Application No: BN/142/21/PL
Site Address: 1 Como Barnham Road Eastergate PO20 3RT
Description of works: Erection of a new two-storey building to contain 2 No 2 bedroom flats with associated parking, bin and bike stores and landscaping. This site is in CIL Zone 2 and is CIL Liable as new flats.

Thank you for your internet representation made on 3rd December 2021 which has been recorded as an objection with the comments as follows:

FROM: S Gardner, 18 Hall Cottages (neighbours)
DATE: 03:12:21
SUBJECT: BN/142/21/PL

Elevations (1:100)

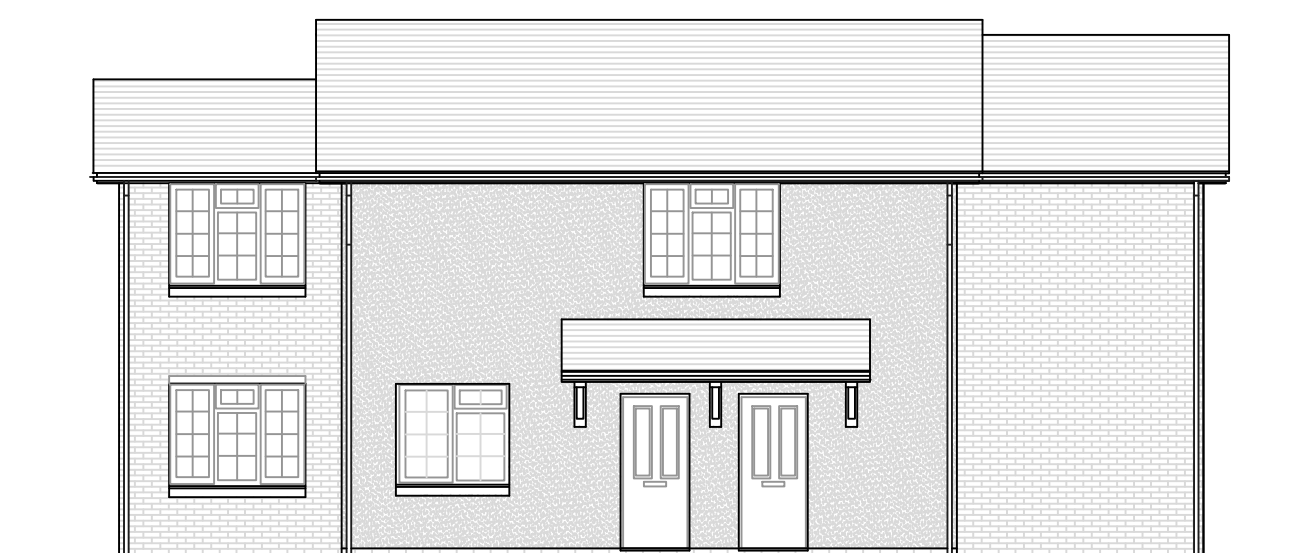
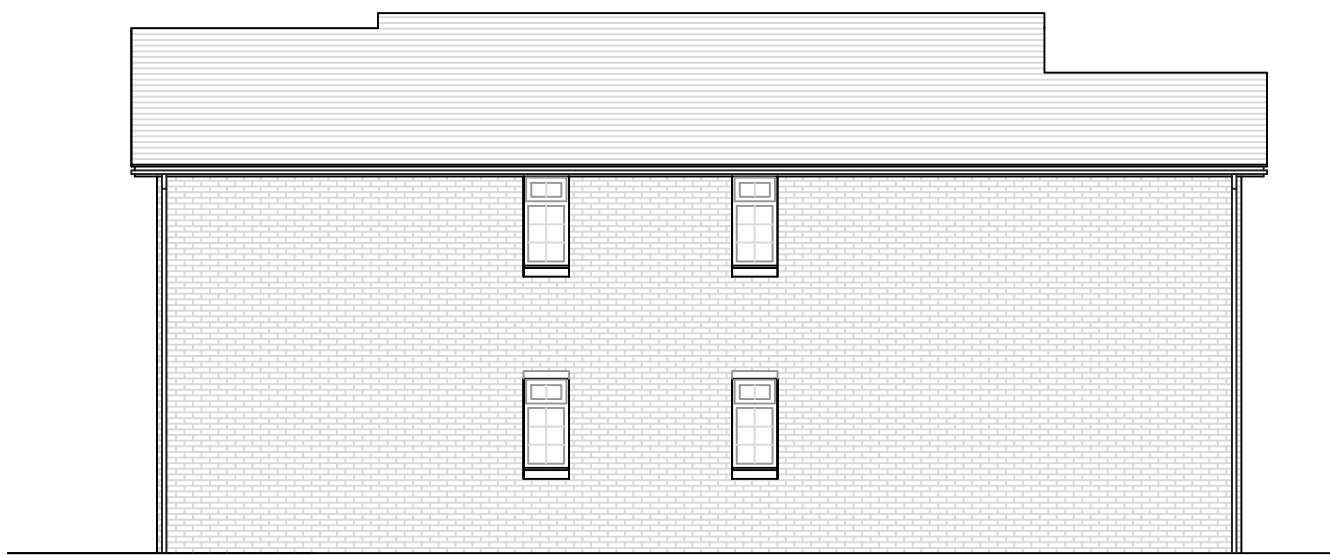
Its unclear from the plans provided if there are windows or fan outlets from both the kitchen and bathrooms of both flats which will overlook the rear gardens of neighbouring properties and potentially invade their privacy. The height of a 2 storey building plus roof would cast a shadow over the rear of the adjacent garden for most of the winter months and in the summer would block light in the mornings to midday. The large oak tree is not shown on the plans, we take it this will be cut down and the roots removed? Will we lose another great tree to urban development ? Also we feel that with the 500+ new properties being proposed in the surrounding fields and the 30 dwellings already granted planning on the south side of Barnham Road added to the 3000 odd new homes in the Arun plan the "need" for 2 new small flats with inadequate parking in this area is not that great ("Under the Arun Parking Standards SPD, a minimum of 2 parking spaces per dwelling would be required for a development of this size and location.") and would lose the rural nature of the area plus there's the water/sewage drainage issue highlighted in the Engineers (Drainage) comments that needs to be properly addressed.
